To Kathryn Hughes Ref: 3/2022/1165 and
3/2022/1166

Subject Conservation Comments

Proposal: Listed Building Consent for the proposed refurbishment of existing farmhouse, conversion of existing attached and detached barns to create three new dwellings, conversion of outbuildings for associated residential use and external works. Resubmission of 3/2022/0727 and 0729.

Site Address: Lower Reaps Farm, Whinney Lane, Mellor BB2 7EL

PROPOSED GROUND FLOOR PLAN SCALE 1:100

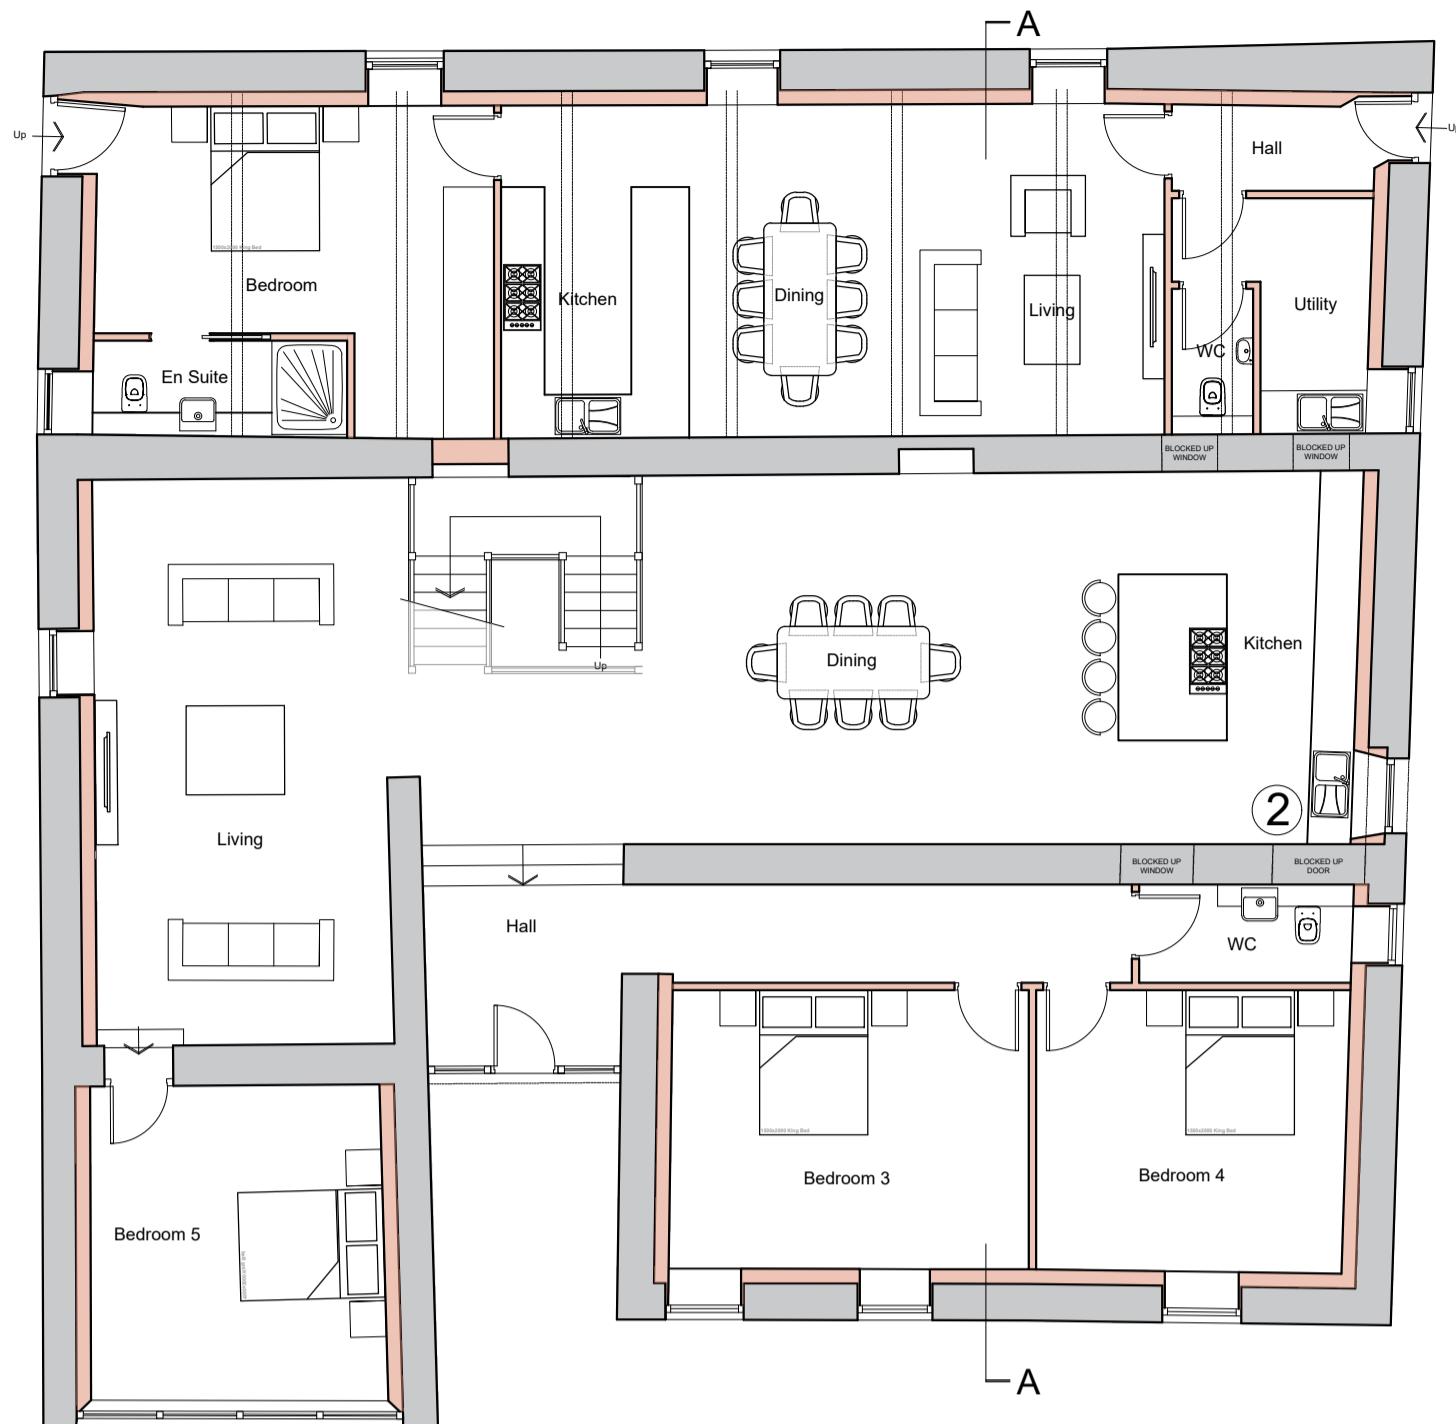
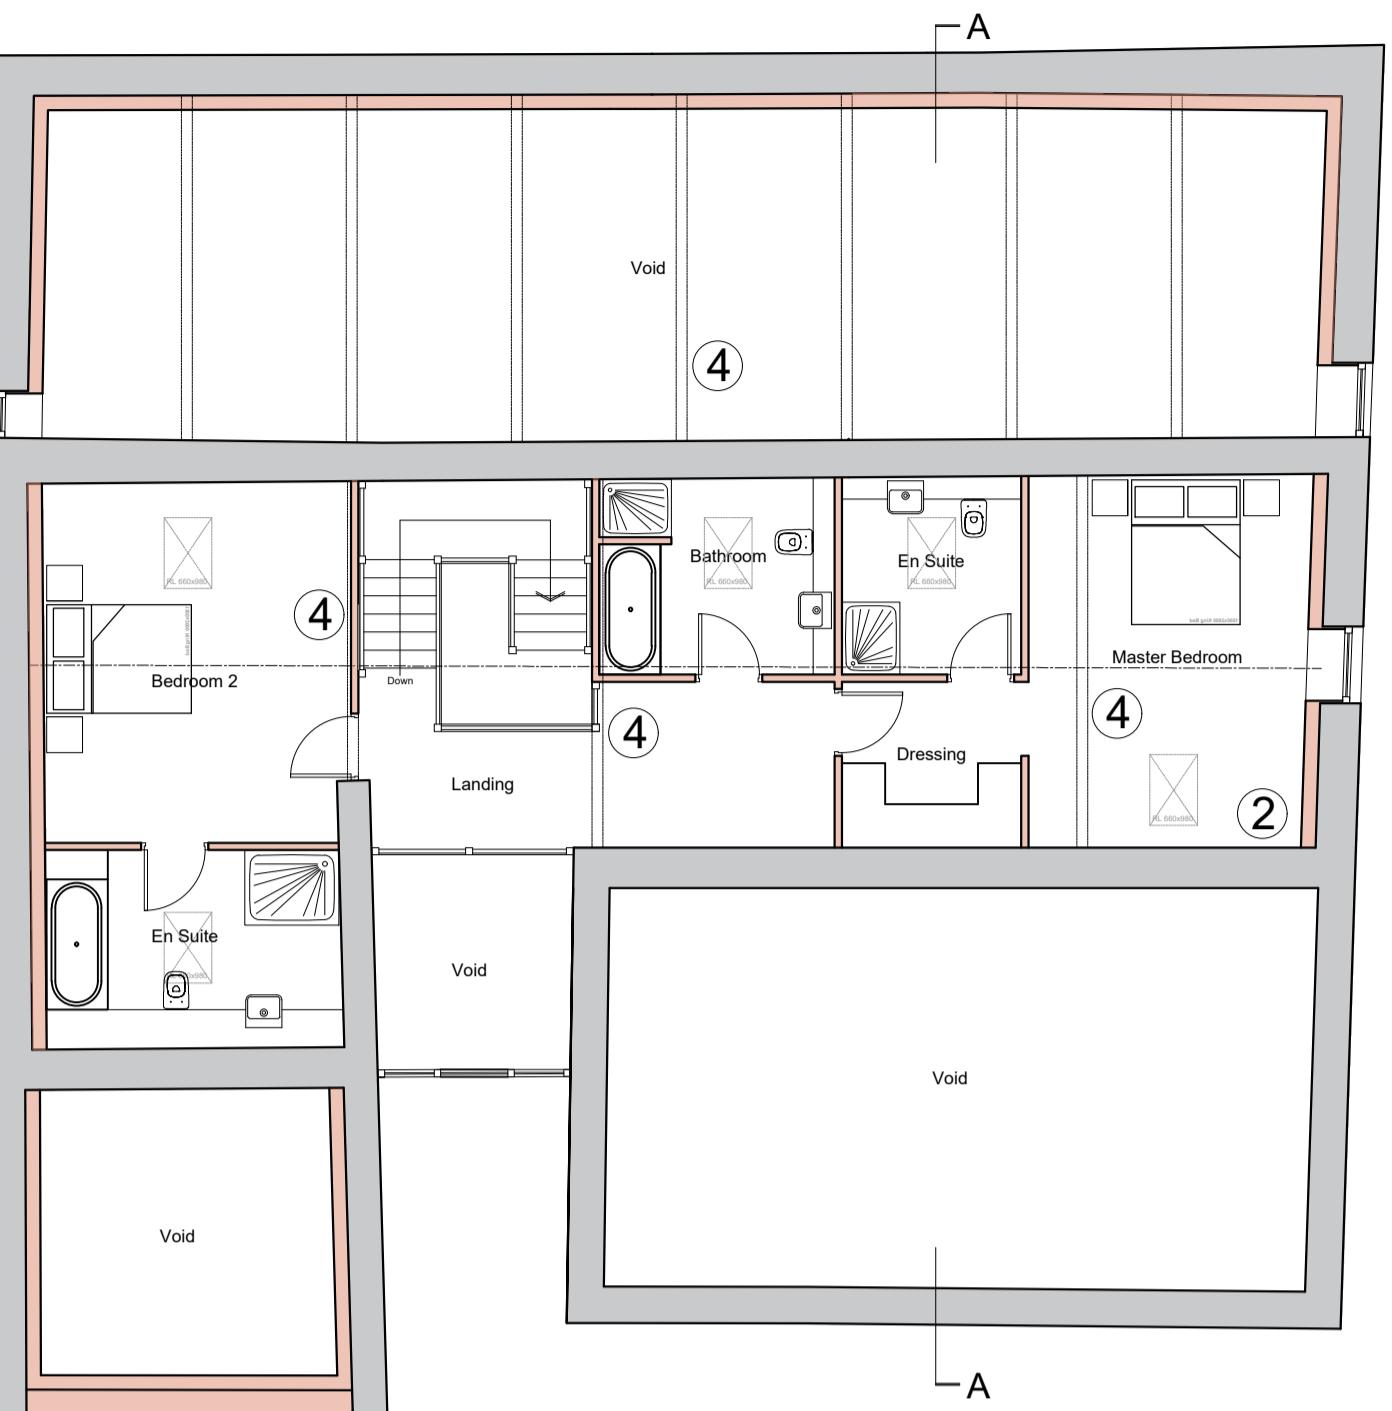
In respect of the detached barn, again, 'in principle' I raise no objection to its conversion to a large five-bedroom family home, with a one-bedroom unit at the rear. Indeed I am supportive of the re-use and conversion as a way of sustaining the value of the group of buildings. Whilst parts of the barn will be subdivided to create a first floor, bedrooms, en-suites and a kitchen in the rear unit, largely the existing plan form is retained and the central core of the barn on the ground floor remains open plan retaining the existing space. The design sees the bedrooms located in the projecting aisles of the north elevation, which I think is an appropriate solution. Likewise, the location of the proposed new staircase in the open plan area at the core of the barn is a suitable solution that will be recognised as the modern installation that it is.

The proposed works also include the blocking up of an existing doorway from the core of the barn to the existing rear cattle aisle. In my view, this is a minor alteration that is required to subdivide the separate units. However, similar to comments above I would prefer to see the blocked up entrance set back in the reveal, as a way of evidencing the former opening.

Drawing Title  
Proposed Barn  
Floor Plans and Elevations

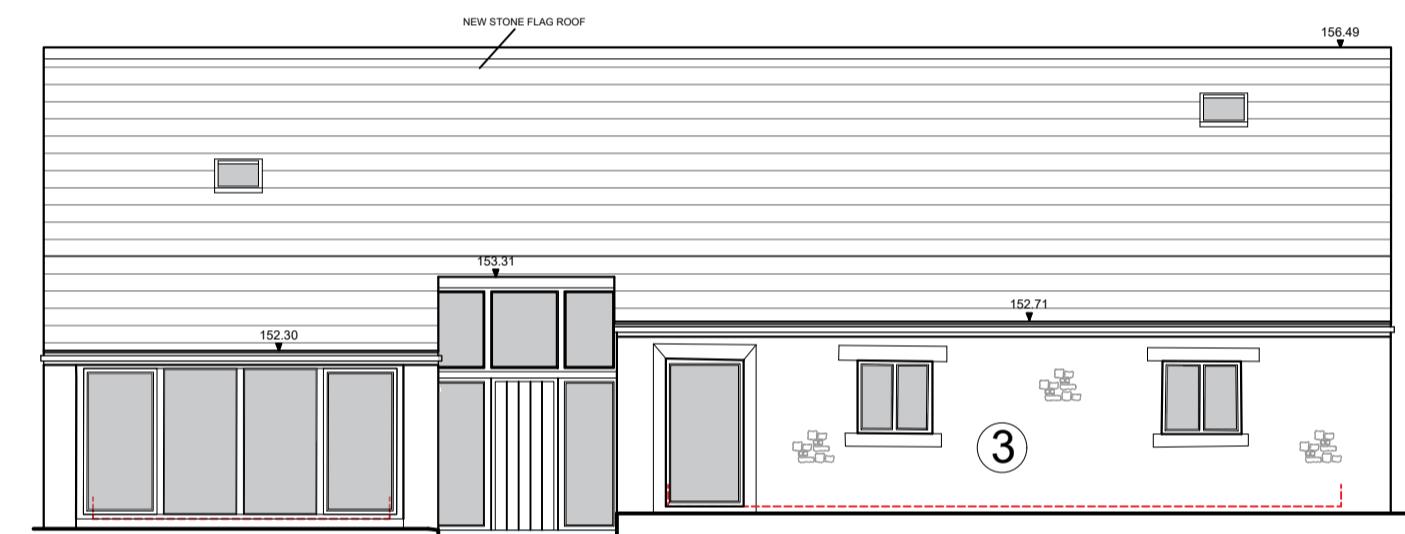
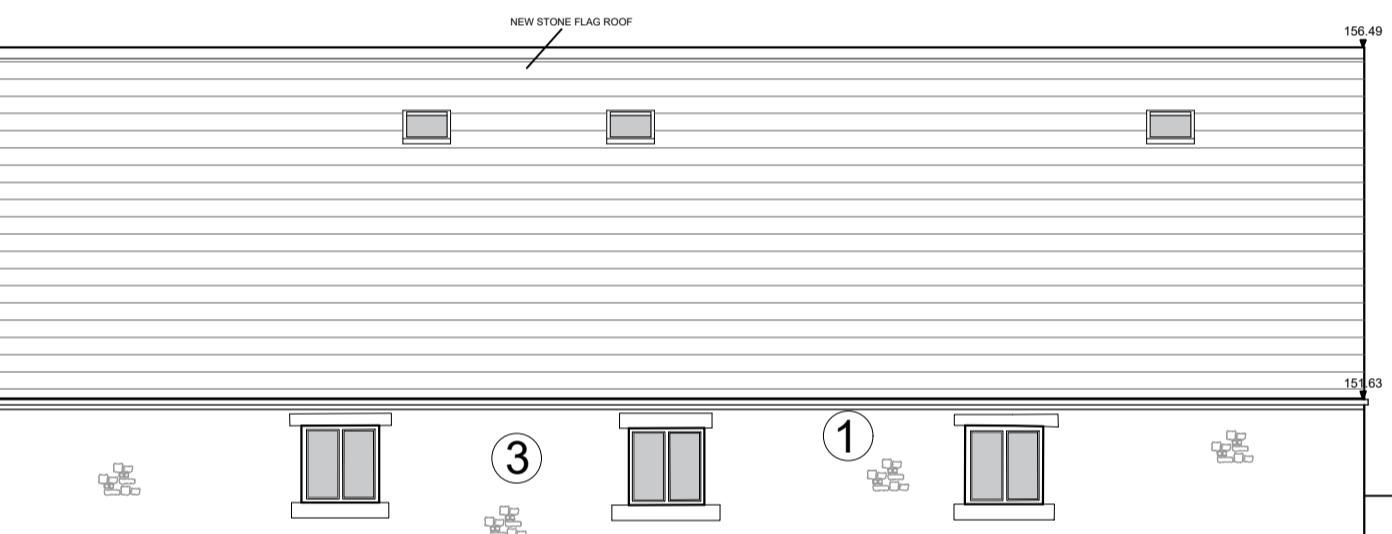
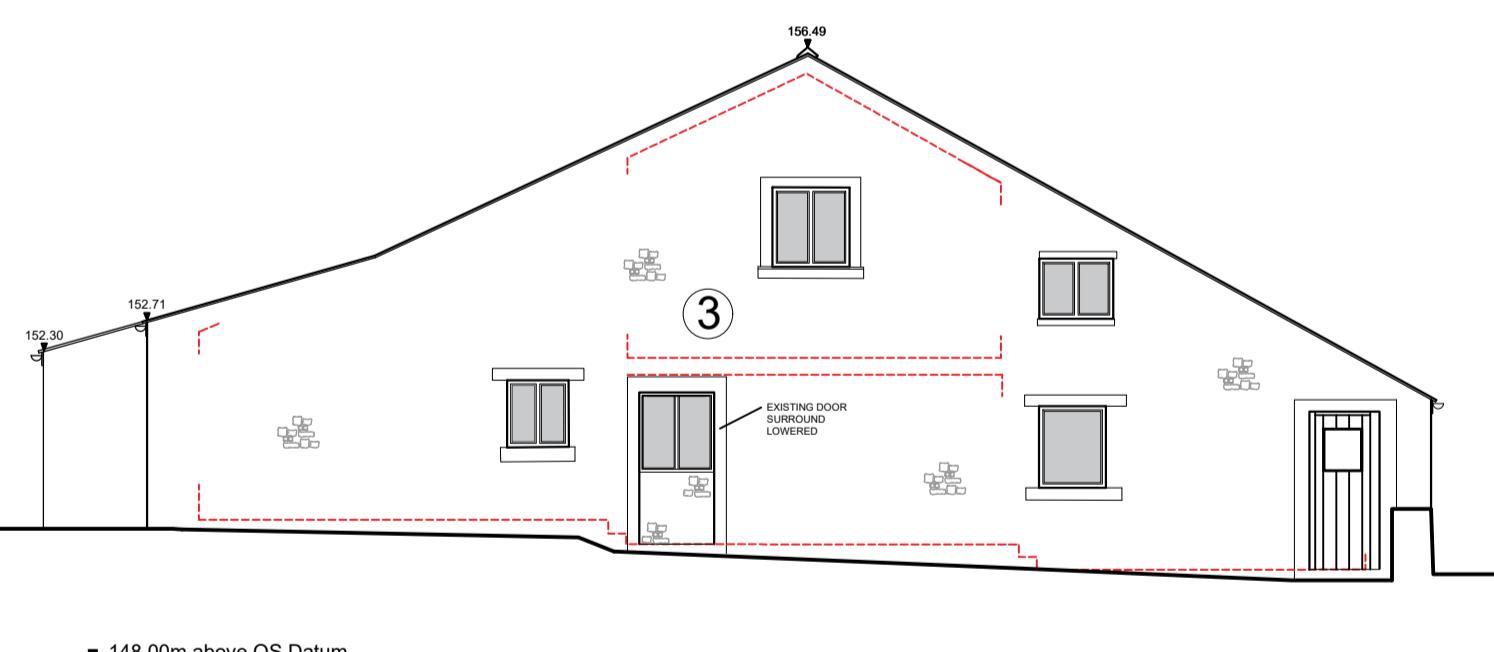
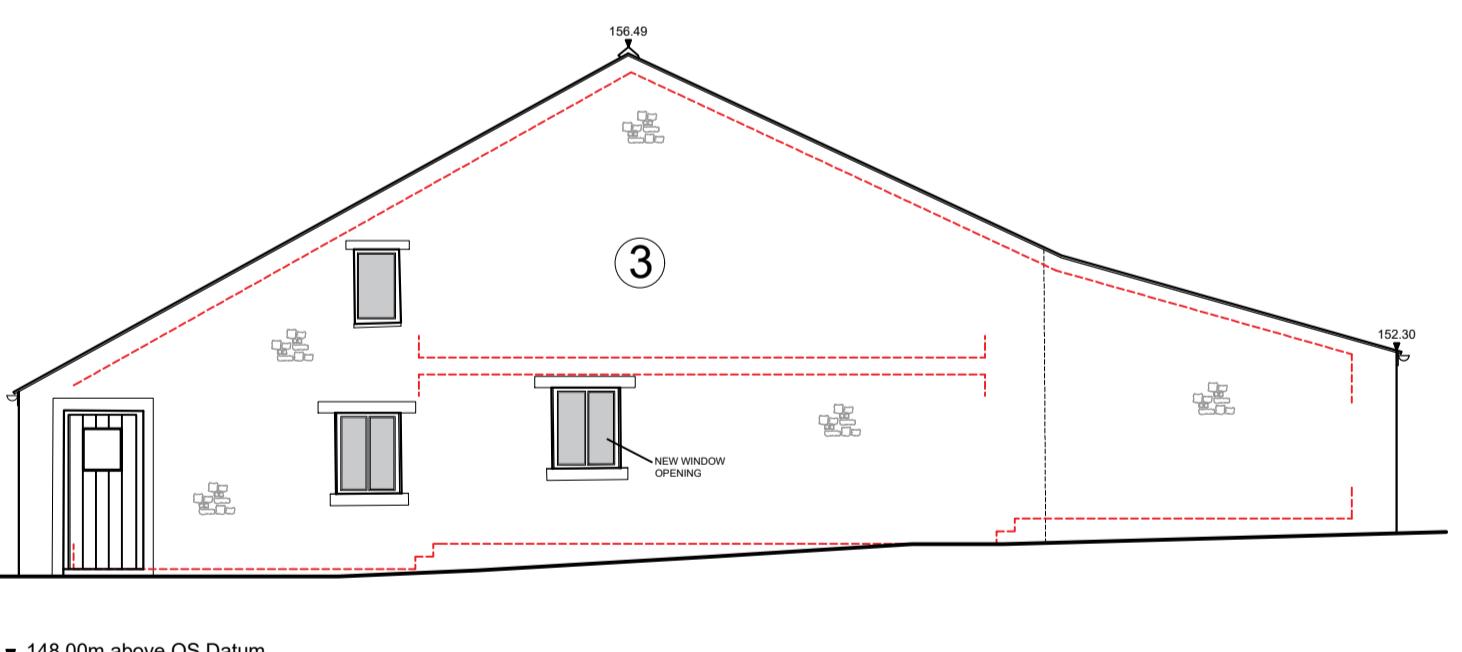
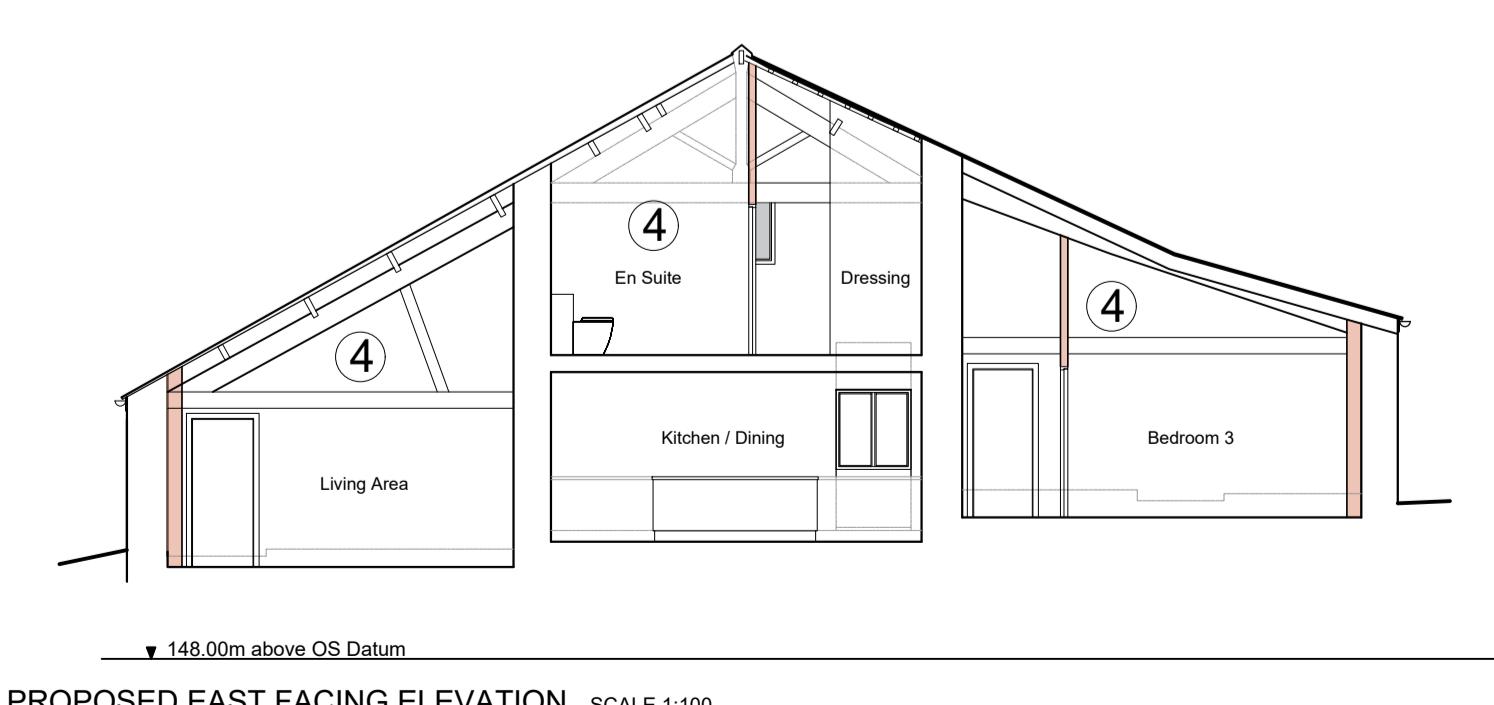
In regards to the external elevations, the fenestration will mostly remain the same, with the addition of a new window on the east (side) elevation, to provide a window that will serve the new living room; and a small number of rooflights to both the roof slopes. Again, this is a minor alteration that will provide some light into the area.

The biggest impact to the exterior of the existing barn is the introduction of the full height glazing to the existing cart entrance and to the eastern side of the north elevation. Whilst large areas of glazing is out of context and character with the building itself and that of the principle listed building; in respect of the cart opening, I accept that it is already in situ and the proposal is utilising this existing opening. Furthermore, the east side of the north elevation has mostly collapsed and what is left is a later addition constructed from concrete. Therefore, I do not think that it would be unreasonable to rebuild this area with the full height glazing, as the historic elements are already lost.
